For and on behalf of  
**BAE Systems**  
Interested Party Reference No.  
**20053944**

## **CLOSING STATEMENT**

**Morgan and Morecambe Offshore Wind Farms Transmission Assets DCO Examination**

**Prepared by  
DLP Planning Ltd  
Liverpool**

Figure 1-1: Environmental mitigation areas at south of Newton-with-Scales

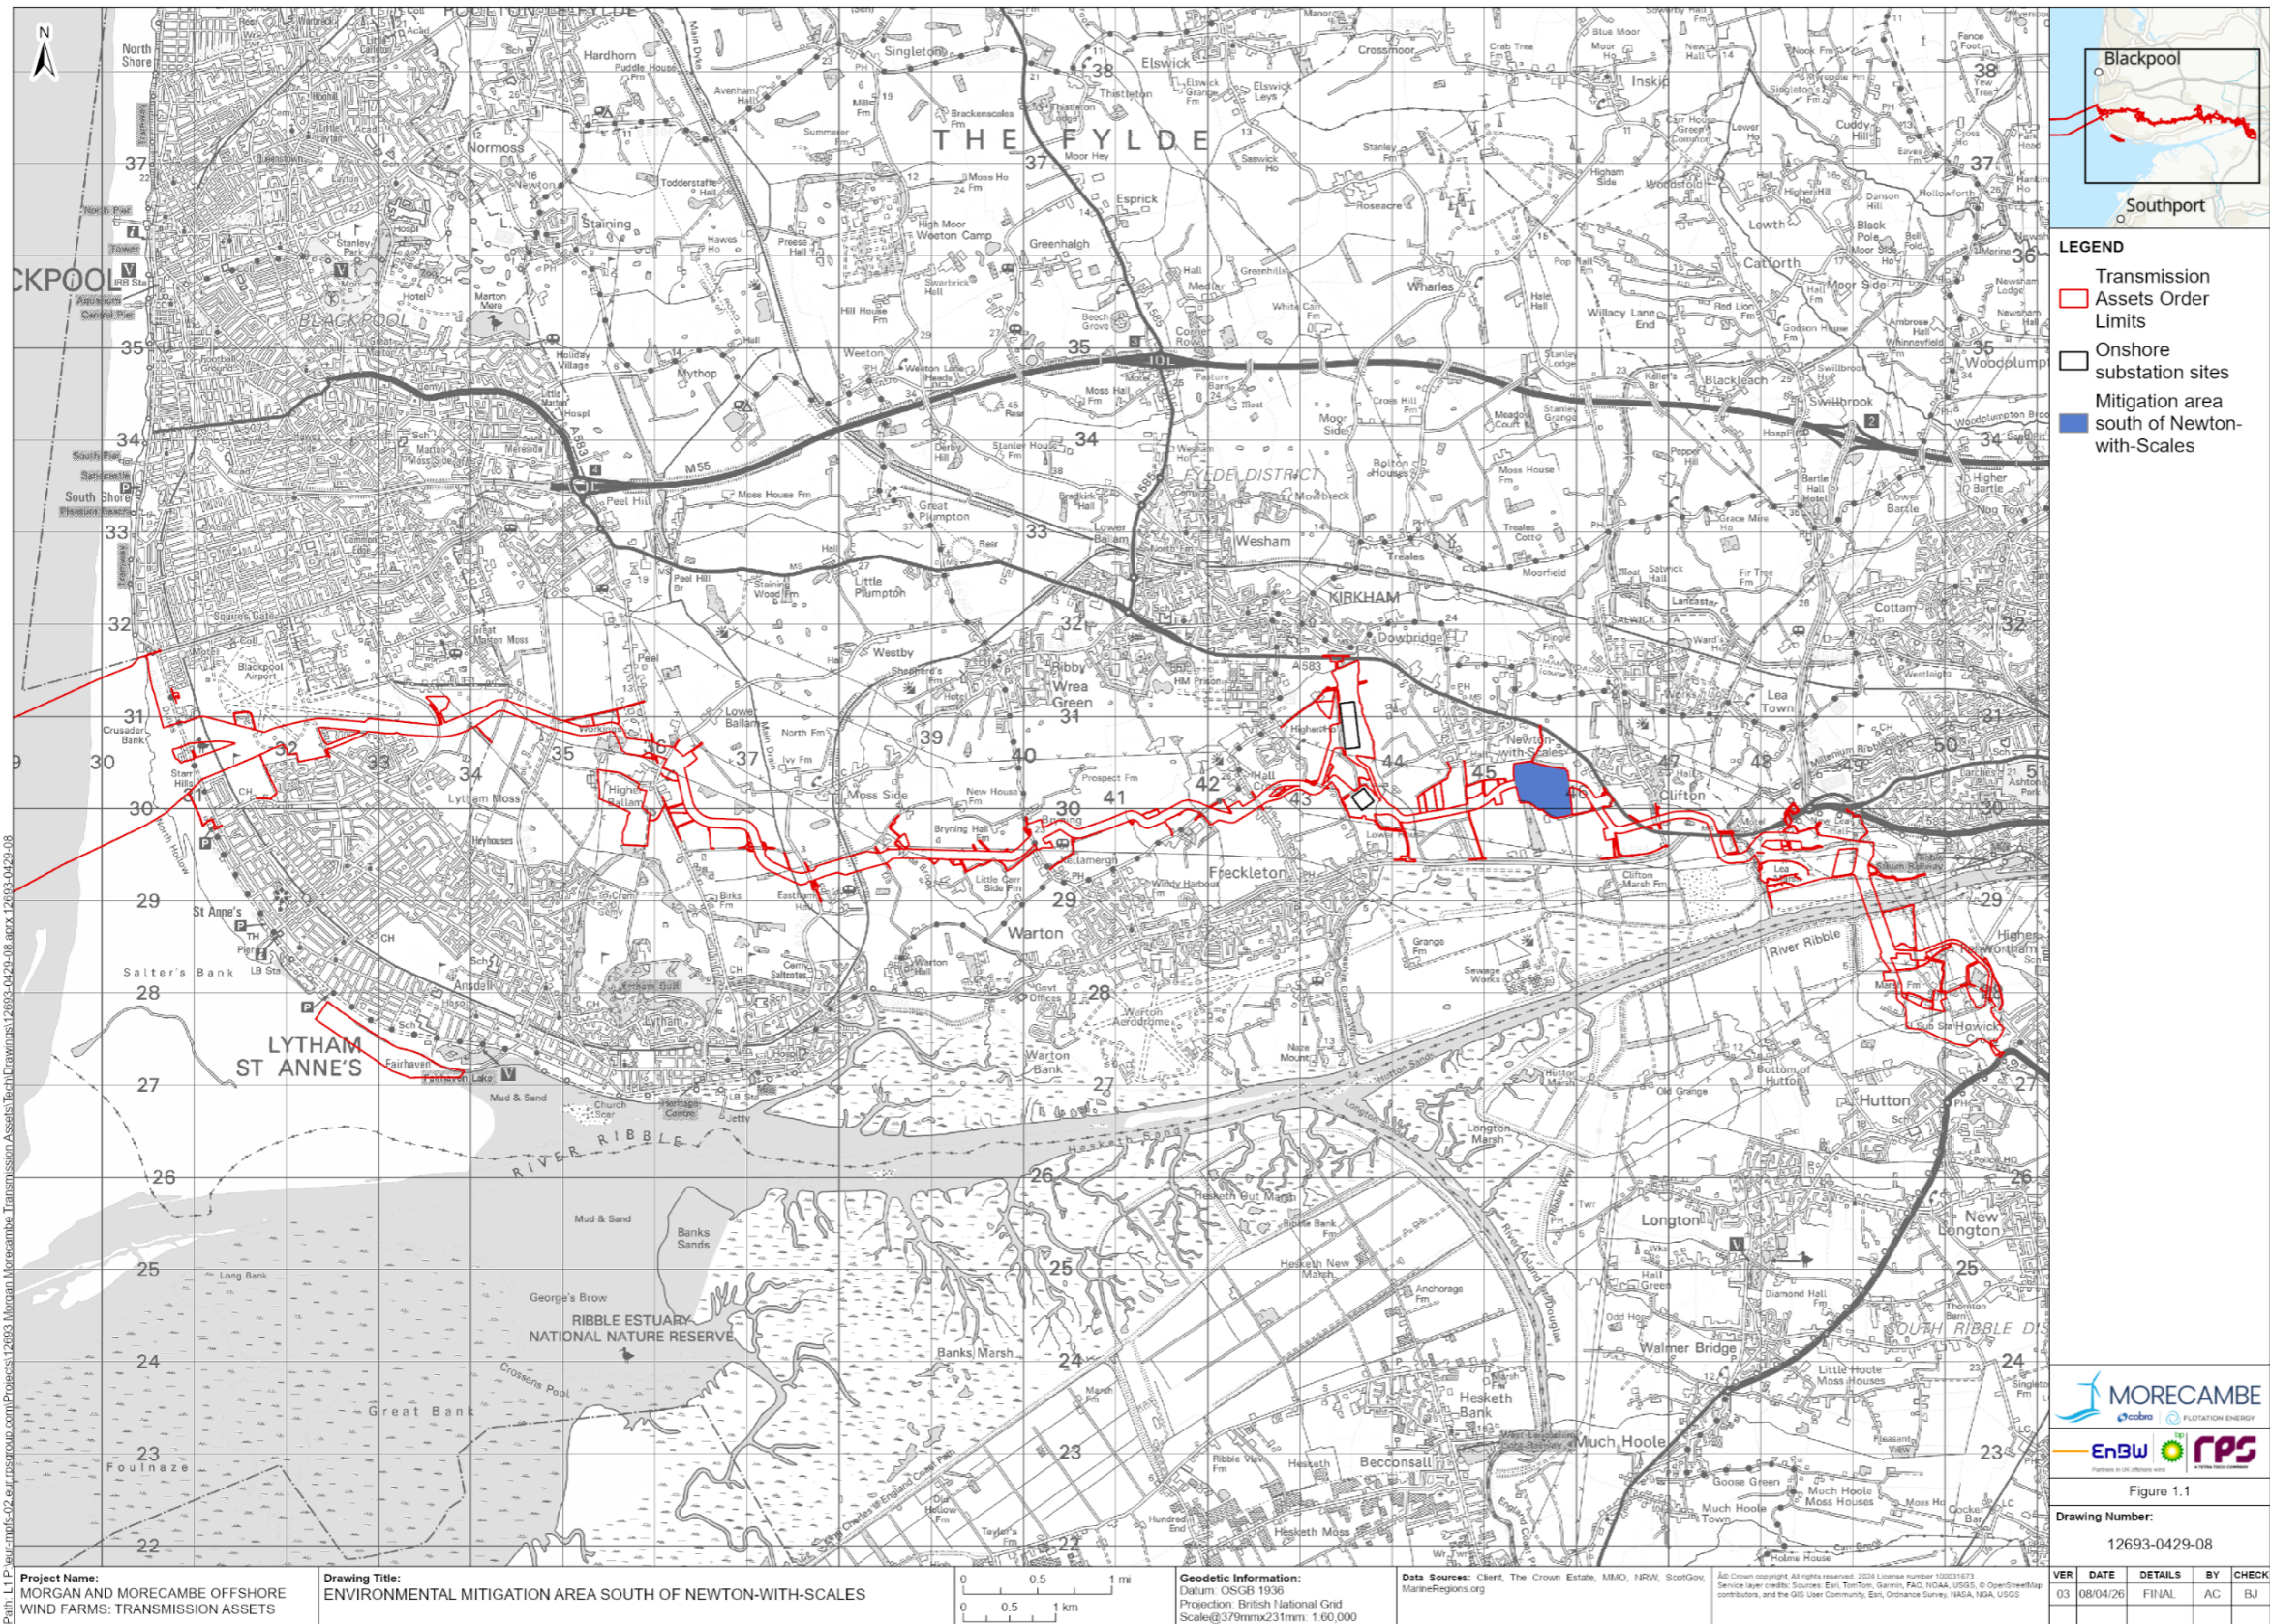
2.4 The MOD / DIO has informed the Applicants that the current proposals for the Newton-with-Scales site could alter the movement patterns of birds in the area, increasing concentrations that cross the approach to Warton Aerodrome, potentially increasing bird strike risk. The MOD / DIO's SME has therefore stated that the mitigation proposed in the Deadline 6 version of the dWAHRA would be unacceptable and the following approach to mitigation should be proposed instead (in order of preference):

- (i) The ecological mitigation site should be located further away from the Aerodrome and its runway approaches than the habitat that it is compensating for; or
- (ii) If mitigation is undertaken at the currently proposed site, it should focus on other farmland birds, such as Corn Bunting or Grey Partridge, not wintering waders or waterfowl which pose a greater bird strike risk; or
- (iii) The mitigation measures proposed in the dWAHRA for the Newtown-with-Scales site must be more detailed and include details of the frequency of monitoring and trigger points for which active mitigation measures are put into place. Without more detail, due to the potential bird strike risk posed by this site, the MOD / DIO cannot support its provision.

- 2.6 Given the concerns raised by the MOD / DIO, BAE Systems cannot support the proposals for the Newton-with-Scales or Lytham Moss Ecological Mitigation Areas. It is noted that the Applicants have identified potential alternative mitigation measures that would avoid the need to deliver these two Ecological Mitigation Areas in its "Comments on the Report on the Implications for European Sites (REIS)" submitted at Deadline 6 (Examination Library Ref: REP6-175). It is the Applicant's position that these alternative mitigation measures would deliver ecological objectives. Given BAE Systems has concerns over the potential bird strike risk from these two sites, it is considered that the delivery of the alternative mitigation measures, if they would avoid bird strike risk increasing whilst still delivering ecological objections, should be preferred and the Applicants' adopted course of action. Further consideration is given to this in Section 4 of this Closing Statement.
